WEST SUSSEX COUNTY COUNCIL CONSULTATION

TO:	Arun District Council FAO: Maria Tomalova
FROM:	WSCC - Highways Authority
DATE:	2 December 2021
LOCATION:	Regis Lodge, 3 Gloucester Road, Bognor Regis, PO21 1NU
SUBJECT:	BR/259/21/PL Proposed change of use from C1 Guest House to 9 Bed. HMO (Sui generis) including internal and minor external alterations.
DATE OF SITE VISIT:	N/A
RECOMMENDATION:	Advice
S106 CONTRIBUTION TOTAL:	N/A

Proposed Site Plan
1:100

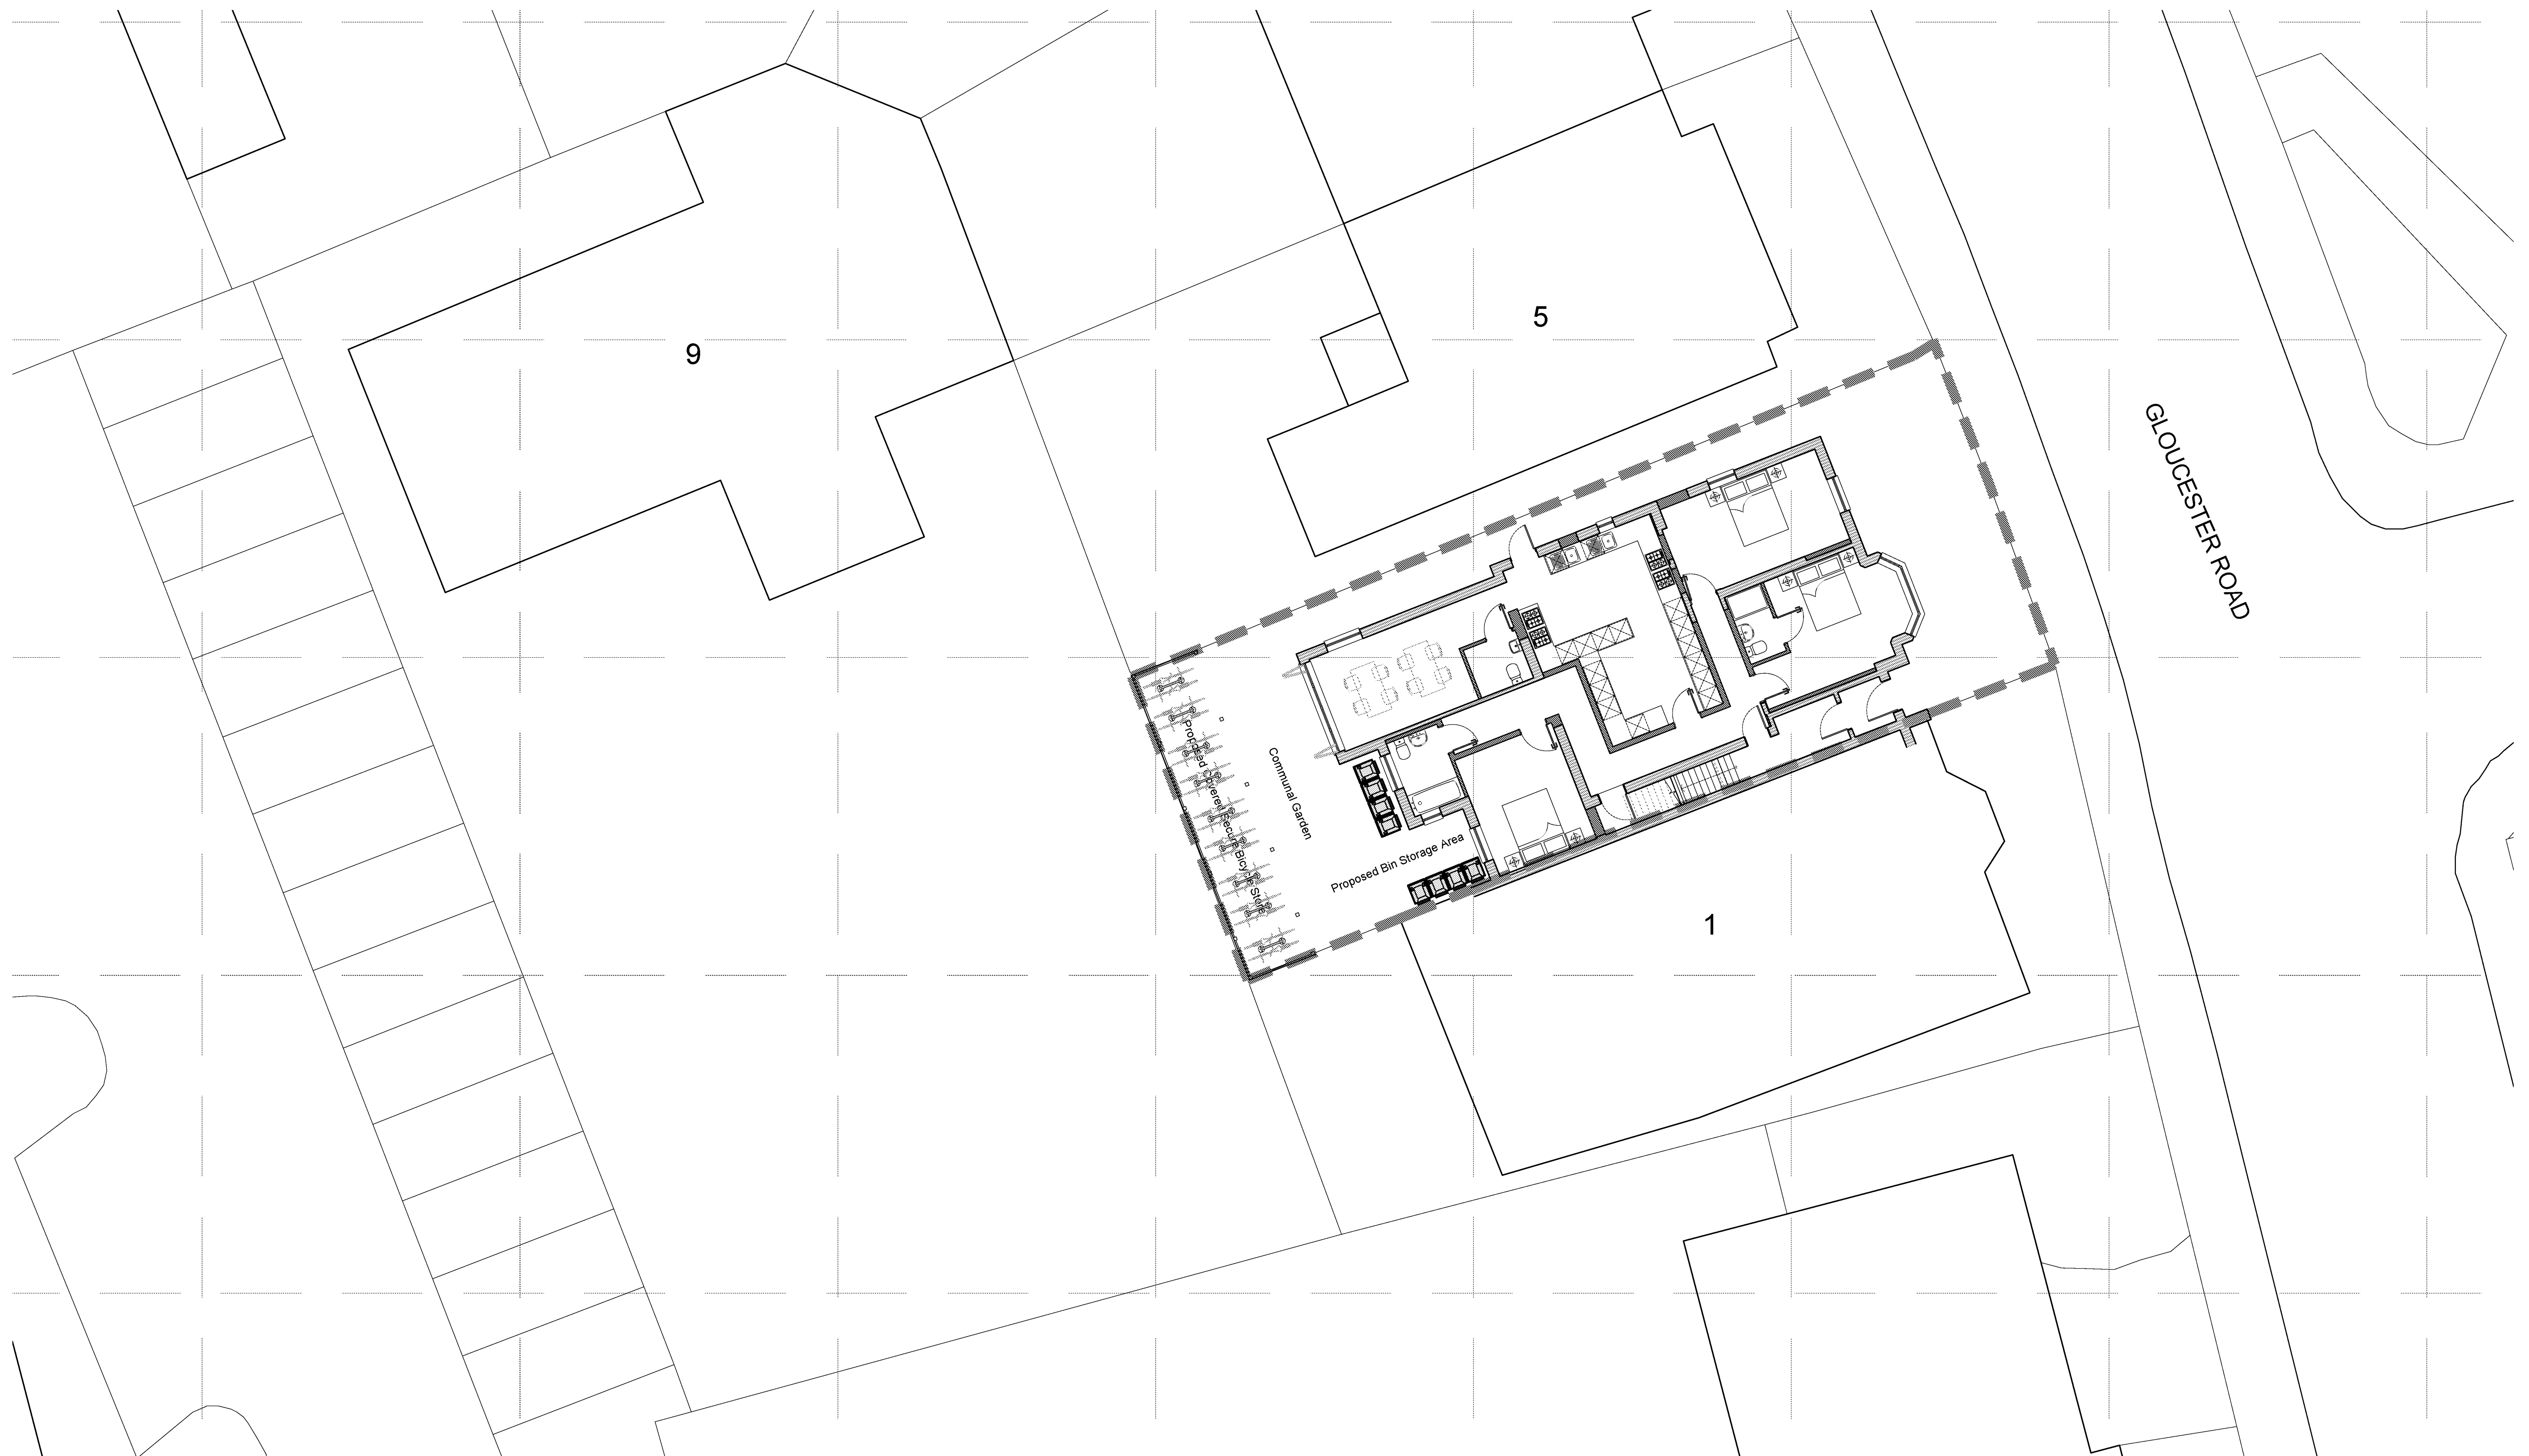
The applicant proposes a nil car parking provision, which appears to be the existing arrangement. WSCC parking standards for HMOs require 0.5 parking spaces per room; therefore, the LHA would expect a parking provision of 4-5 parking spaces for a development of this size. As a nil parking provision is proposed, vehicular parking would have to be accommodated on-street.

Cycle parking

No part of the development shall be first occupied until covered and secure cycle parking spaces have been provided in accordance with plans and details to be submitted to and approved by the Local Planning Authority.
